**Proposed Mixed Commercial and Retail Development,
Stages 1A and 2, Site 43/44, Sydney Olympic Park
(SSD 12_5676 and SSD 12_5677)**

October 2013

Response to Submissions Report

7 Level 6
1: 500

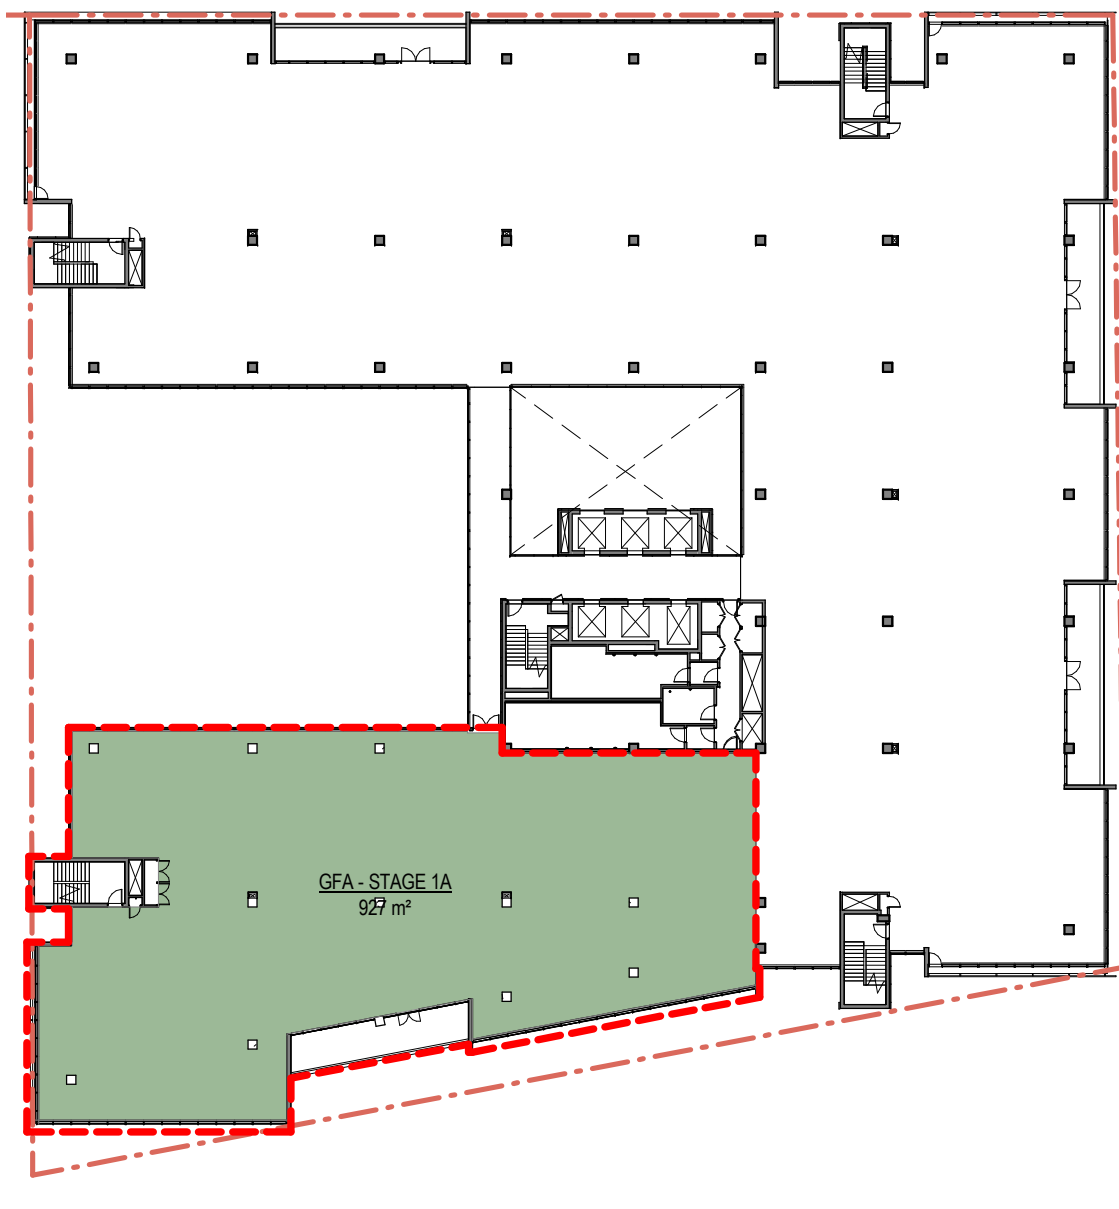
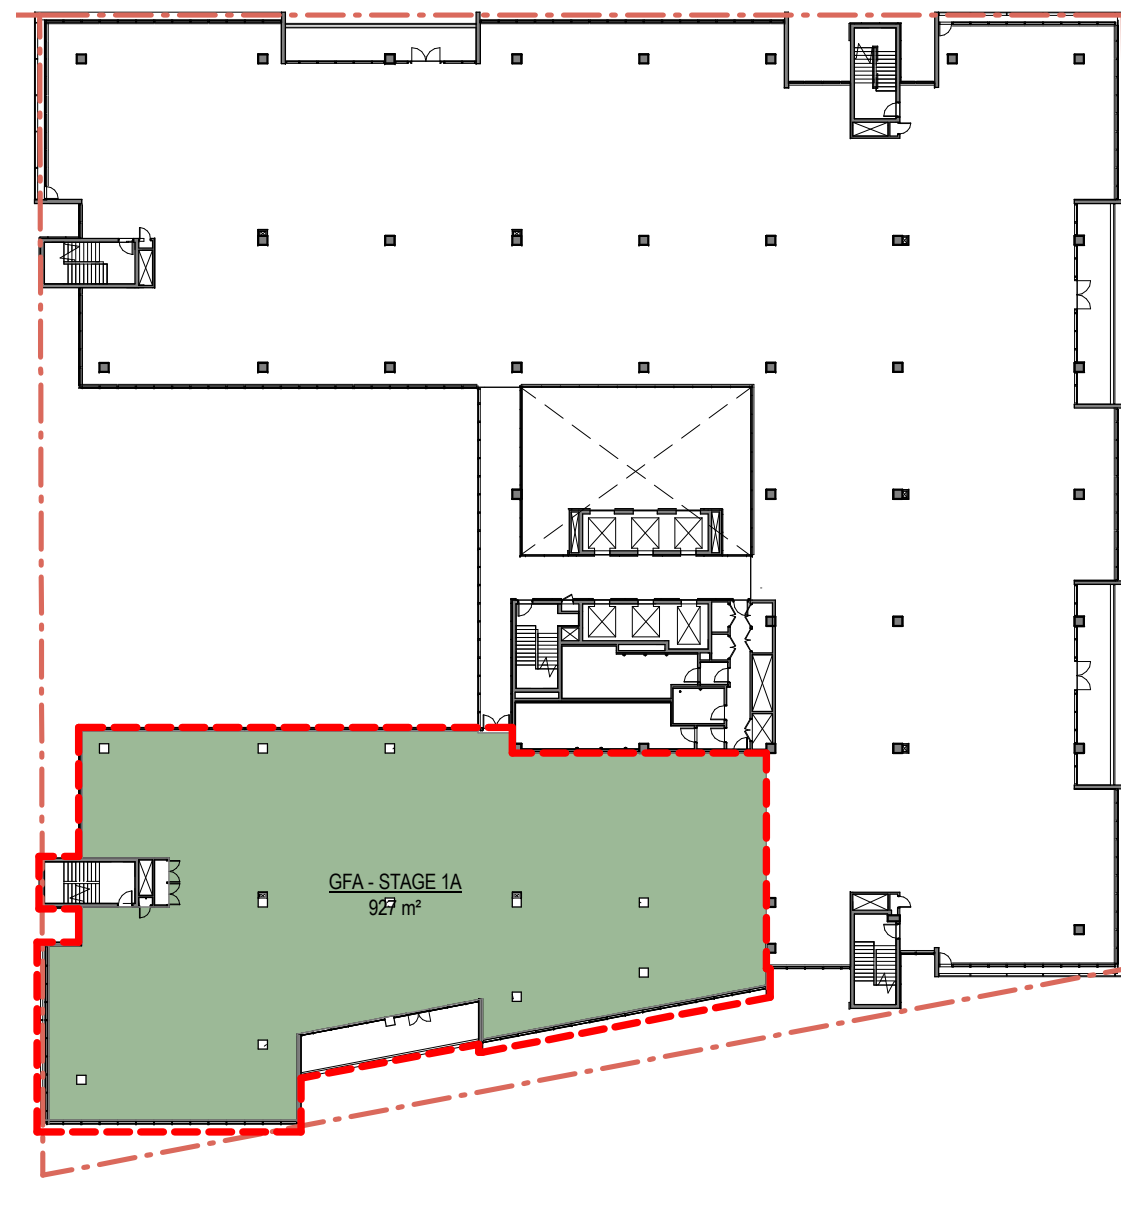
In addition, there is a slight change to the Gross Floor Area for Stage 1A from 6,920m² in the EIS supporting the SSD application, to 6,917m² in this Response to Submissions Report. The 6,919.7m² GFA is comprised of 6,489m² commercial GFA and 428m² retail GFA, with retail Net Leasable Area (NLA) of 409m². The architectural drawing showing the GFA schedule for Stage 1A has been amended to reflect the amended total GFA – refer **Attachment A**.
